As part of the representation process Fen Drayton Parish Council will be submitting a written representation, as requested, by 15th June and the SCG by 26th June.

Need for site inspection to assess proposed A14 impact on Fen Drayton Town Lands and flooding from Covells Drain

Drawing title: **LAND PLANS REGULATION 5(2)(i) SHEET 13 OF 40**

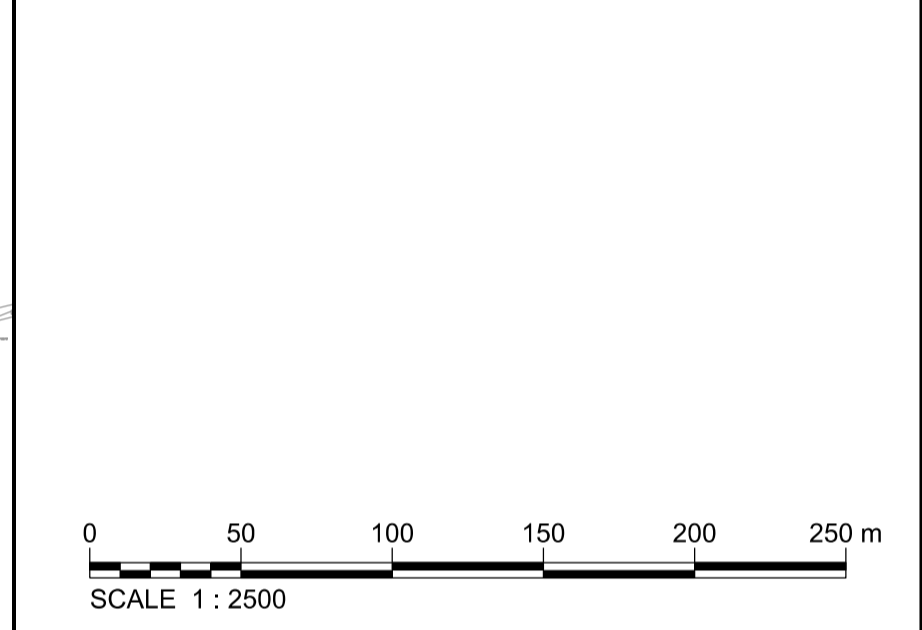
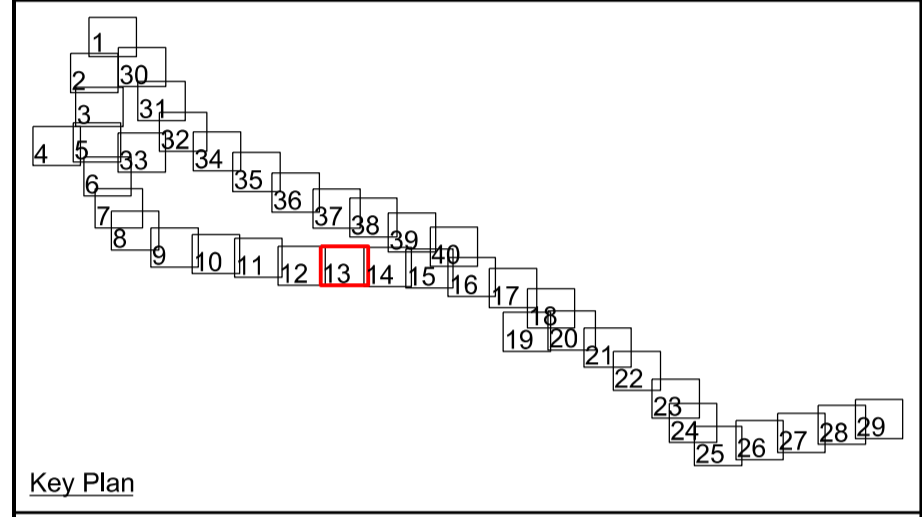
The map below is taken from the General Arrangement Regulation Sheet 13 reference A14-JAC-22-E1-DR-Z-01013. The Town Lands is the field shown on the right of the map, 300 metres South –East from the junction of the road from Fen Drayton with the A14, on the North side of the current A14. The flood risk point occurs at the junction of the road from Fen Drayton to the A14 (top left in the map) where Covell's Drain watercourse comes under the A14 and then runs North parallel to Cambridge road.

to farm the land by a neighbouring field. The proposed A14 improvement will stop up many field access points along the present A14. Even though the existing A14 will be de-trunked and will pass into the responsibility of the local authority, access from the de-trunked A14 to the Town Lands will be stopped up (see drawing number A14-ARP-ZZ-00-DR-Z-00316). According to the General Arrangement Sheet 13 (drawing number A14-JAC-E1-DR-Z-01013) the present access will be part of a compulsory purchase order taking 3882 m² (0.3882 ha) of land bordering the current A14. From the field to the road, the access will be cut by: a hedge; a culvert or ditch; a footpath and a cycleway, all running parallel to the A14. Land not used for these structures will be planted as grassland. The Planning Application appears to make no provision for alternative access, so it appears that it will not be possible, legally or physically, to access the Town Lands from the A14. In effect, the land will become isolated, except by passage over adjoining land. It is not clear that there is a public right of way over the neighbouring land so access via this route is facilitated by local agreement. Such agreement could be withdrawn at any time.

The need to retain access from the A14 as part of the upgrade development is essential to maintain this income for the Parish.

Public drain no. 1 (Covells Drain) has a significant catchment to the South of the A14, running under the road then parallel to Cambridge Road towards the River Ouse. There is a balancing pond proposed (indicated on the left of the map) but there are large areas of road development to the immediate South and West which have a large area of run-off and it is likely that at times of heavy rain, the volume of polluted water could be substantial. This will debouche into the existing public drain. There is an existing problem, which occurs regularly, of overflow of water onto the road and land (a serious impact on crops) at the road junction here. This is caused primarily by the drain executing a dog-leg immediately after it emerges from the culvert under the A14 before it assumes its normal course northwards. Any excess run-off will exacerbate this and it is suggested that there is an opportunity now to straighten the watercourse.
